MP 10_0025 COMMERCIAL BUILDING C4 PROJECT APPLICATION MODIFICATION 1

CITY OF SYDNEY COMMENT ON 'RESPONSE TO AGENCY AND PUBLIC SUBMISSIONS'

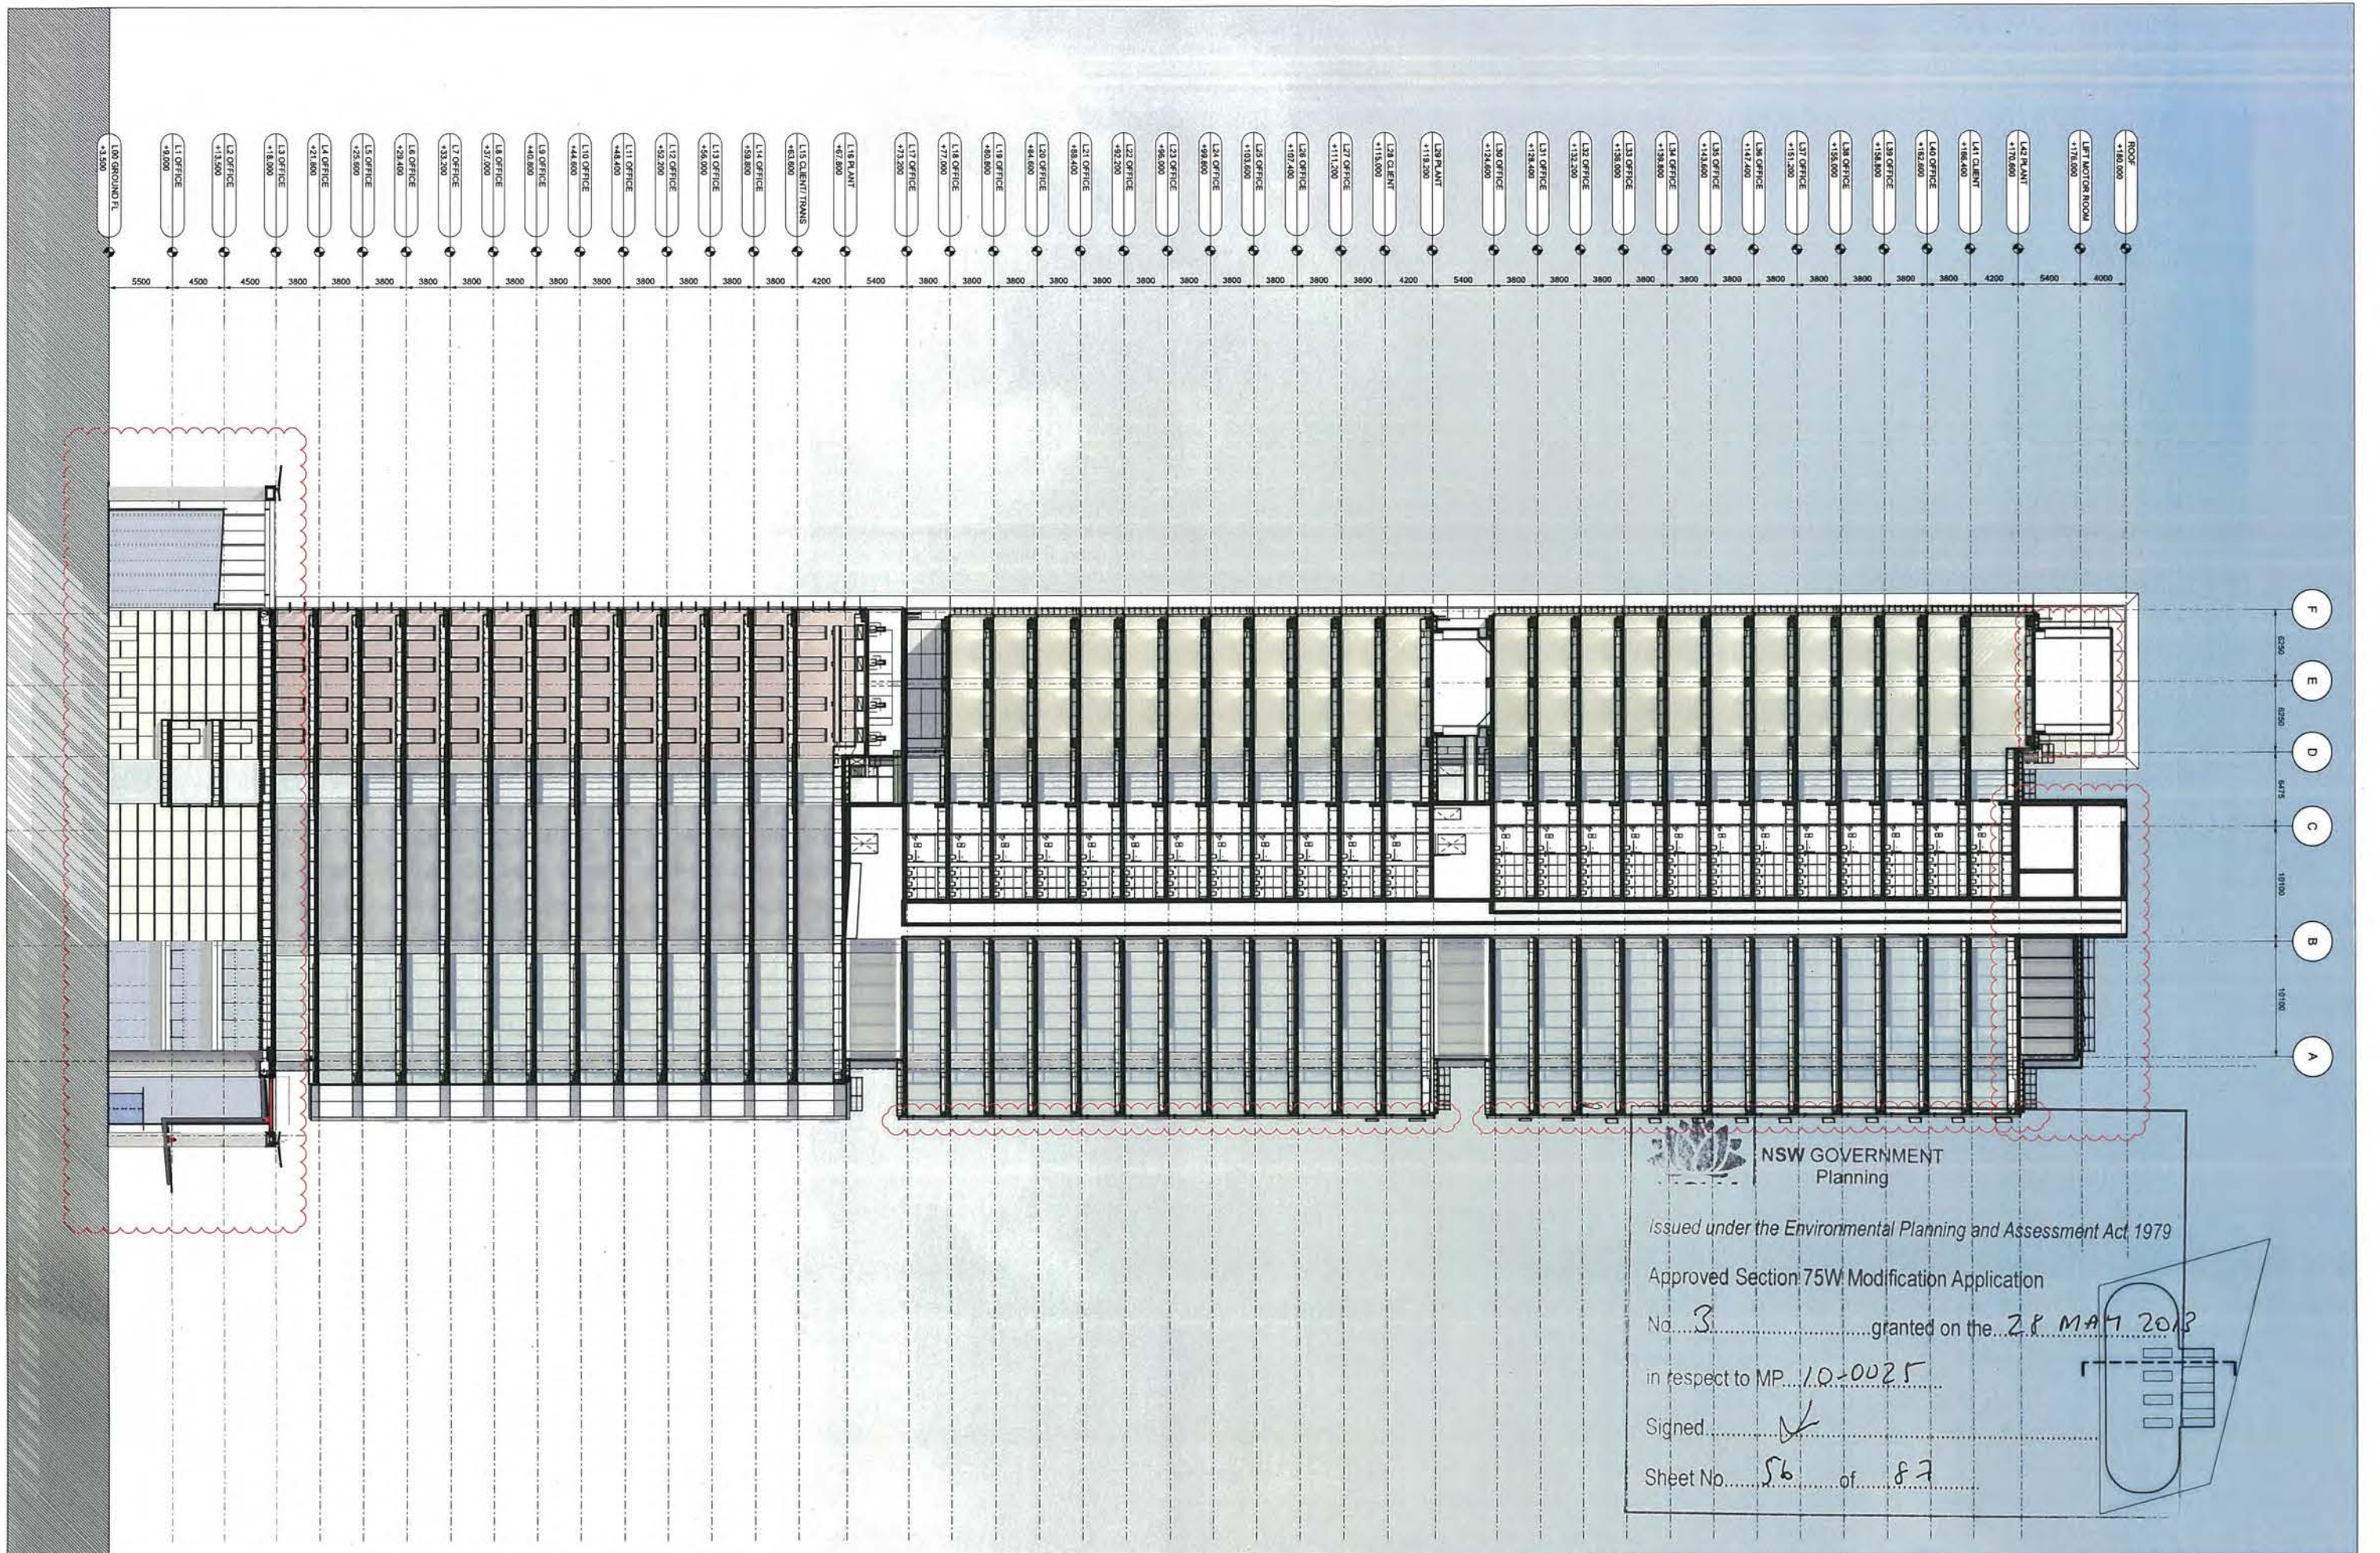
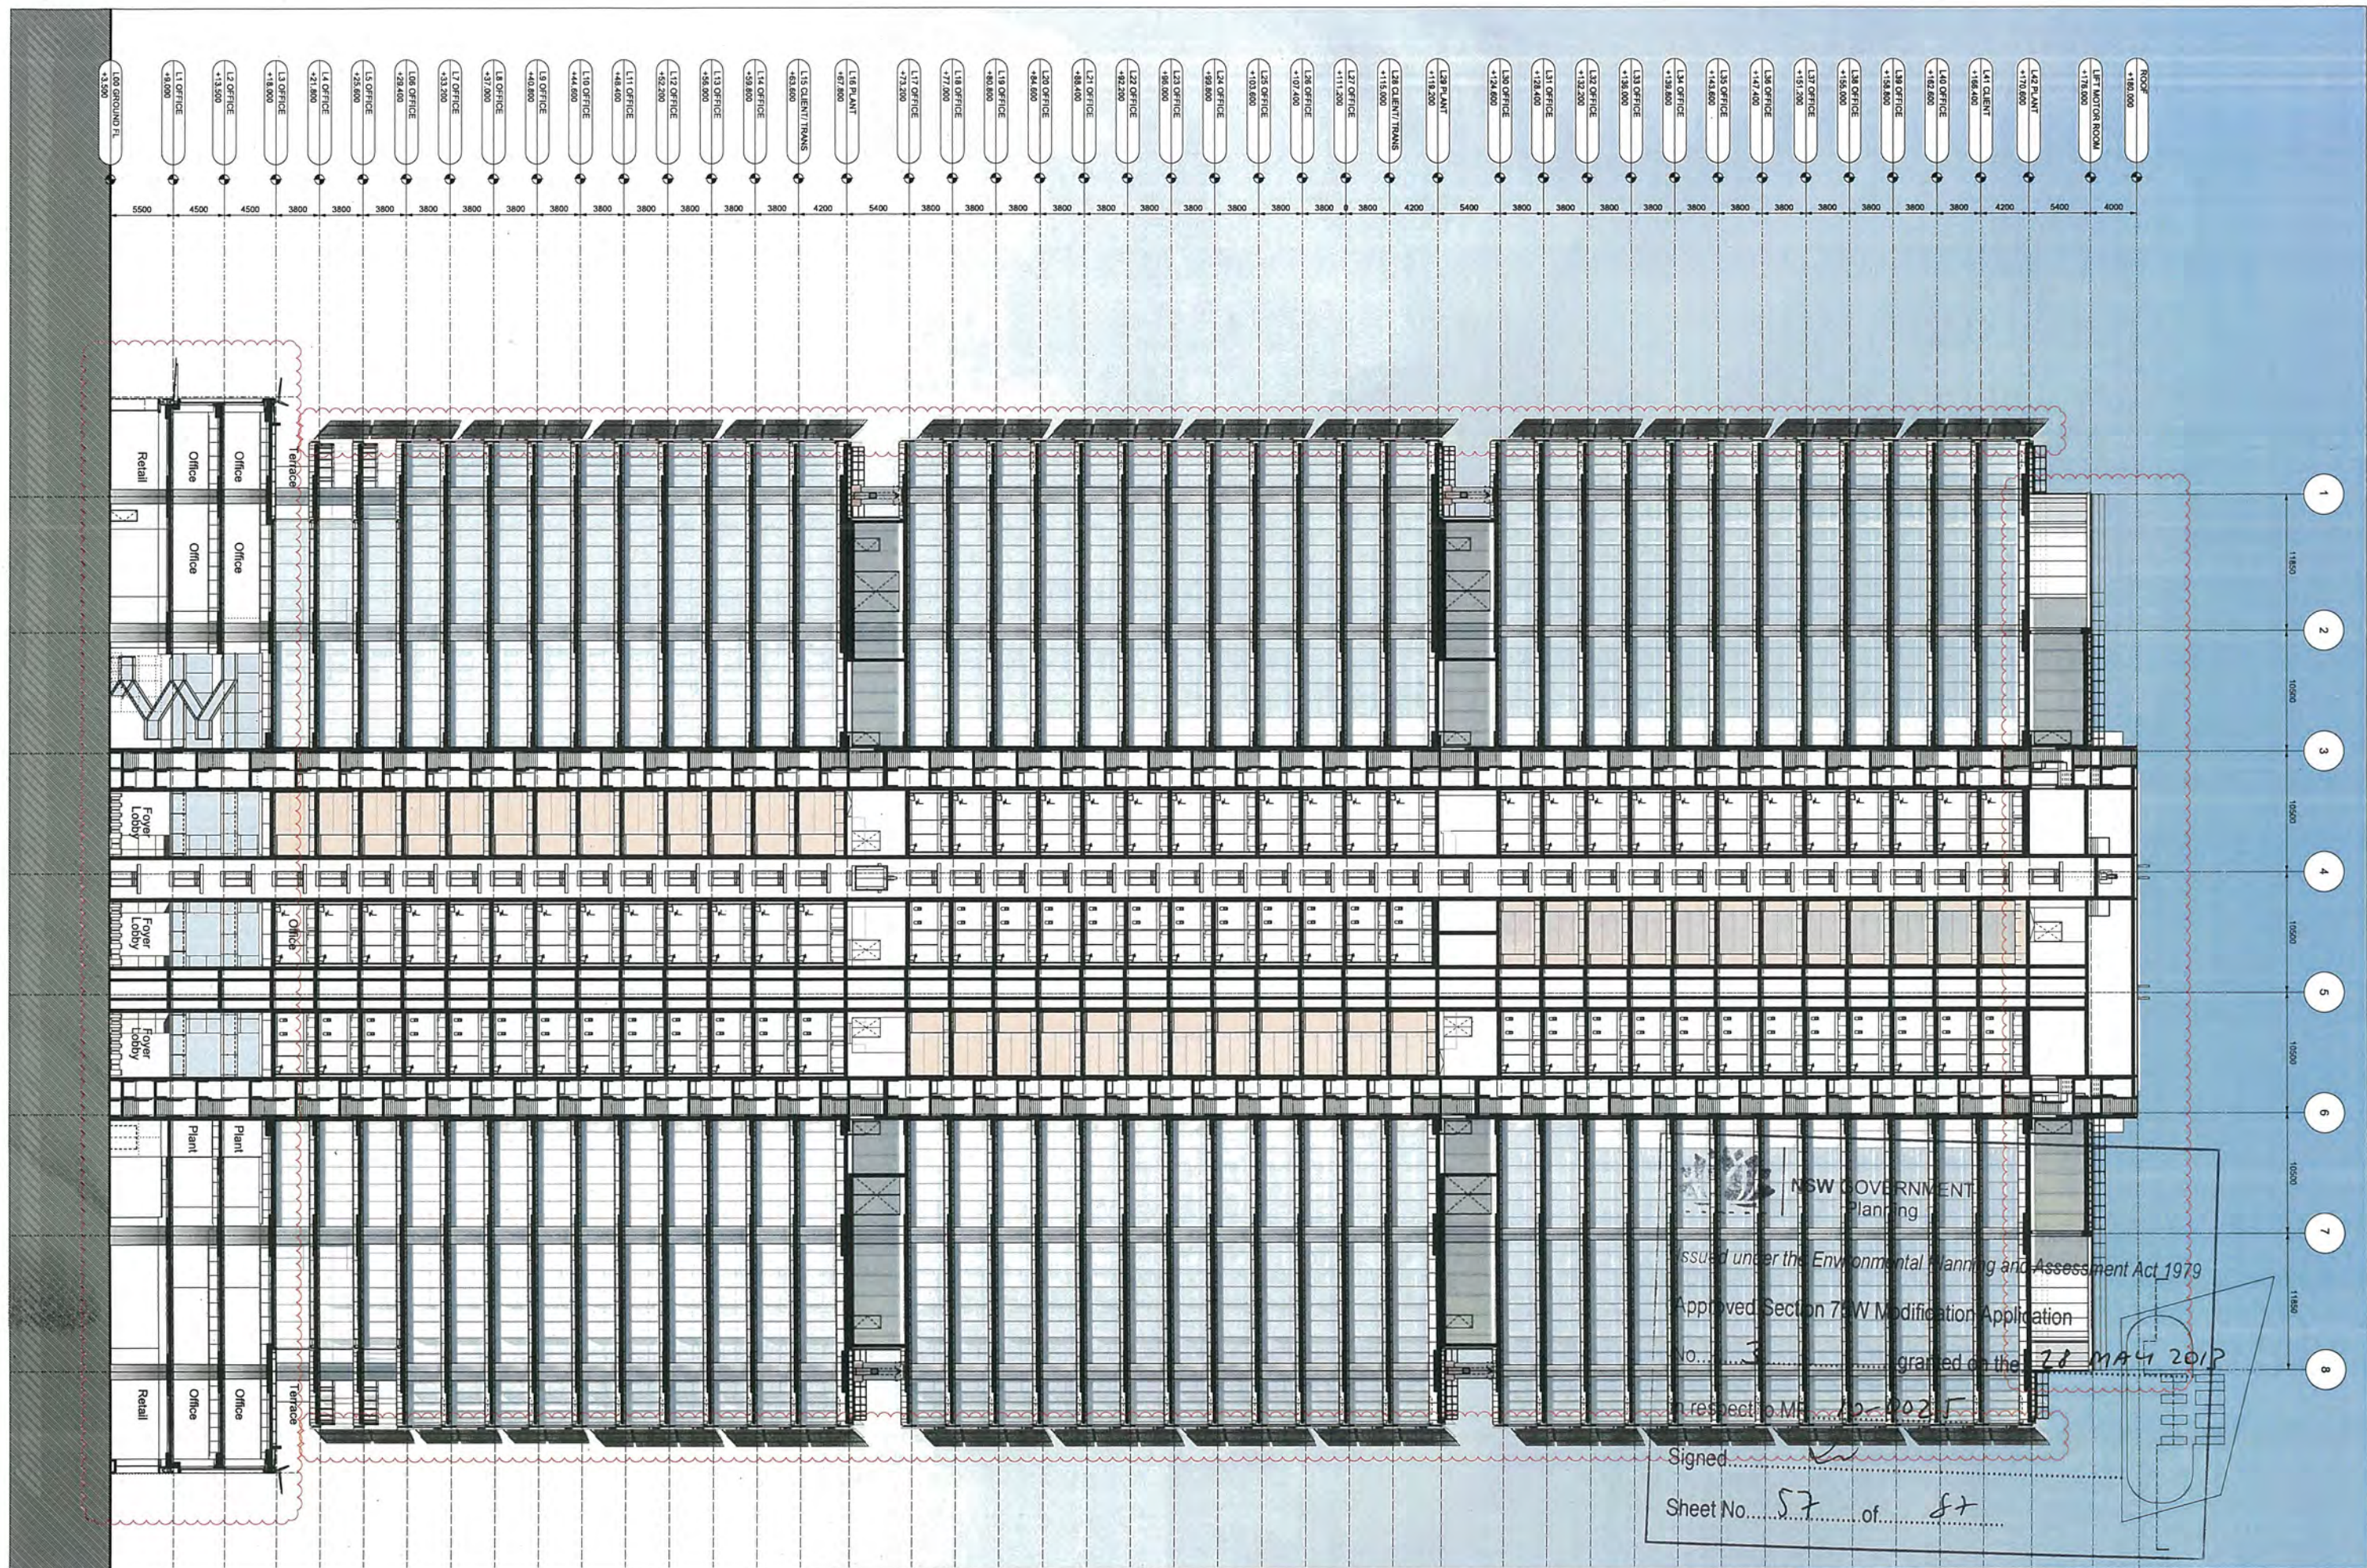
2	<p>Previous (February 2011) Recommendation 2 - The proponent must provide sections which show how the forecourt successfully changes level from RL 3.6 to (average) RL 2.2, and document why this level change is required.</p> <p>City of Sydney comment on Mod 1 application: It is noted that as a result of design development, the RL at the lobby has been lowered to RL 3.5, which results in a grade change of 1.11 metres between the lobby and the level of Hickson Road. The proponent notes that this level change is consistent with the site drainage expectations.</p> <p>DP&I should ensure that all alignment levels for new areas of public domain are designed to integrate with the existing public domain on all edges so that proposed finishes marry into existing surfaces along Hickson Rd and Globe Street/ Lime Street. This may require setbacks. Car parks should be recessed so that they do not present blank surfaces or generate access problems. New roads should follow the ground plane to assist with overland flow paths.</p>	<p>The current modification application does not seek to amend the approved ground levels of the building (RL 3.5). This comment is therefore not relevant to the current application.</p> <p>The existing Condition B6 of the approved project requires detailed design documentation of how the road pavement and footways match into the existing public domain.</p> <p>Existing Condition B7 of the approved project relates specifically to the alignment levels of Globe Street, City Walk, Southern Lane and Shelley Lane, being the new public domain to which the approved Commercial Building C4 relates. It requires footpath alignment levels for the development to be submitted to the PCA for approval. The submission must be accompanied by a plan prepared by a Registered Surveyor showing the existing location, size and levels (AHD) of all service covers, trees, poles and street furniture, kerb, gutter and alignment levels of 10 m cross sections, alignment levels at proposed and existing vehicular and/or pedestrian entrances within the footway adjacent to and extending 20 metres past either side of the site.</p>	<p>The comment is highly relevant to any condition that might be applied to the current modification application. These conditions only go so far in addressing these concerns while the plans fail to indicate adherence to the conditions. The only effective condition to provide some assurance in this regard is B6 which simply states 'Detailed design documentation of how the road pavement and footways match into the existing public domain'. But to whose satisfaction? The City, as likely future road authority should be consulted.</p> <p>As the plans indicate that these level changes are still proposed, the City's original comment</p>
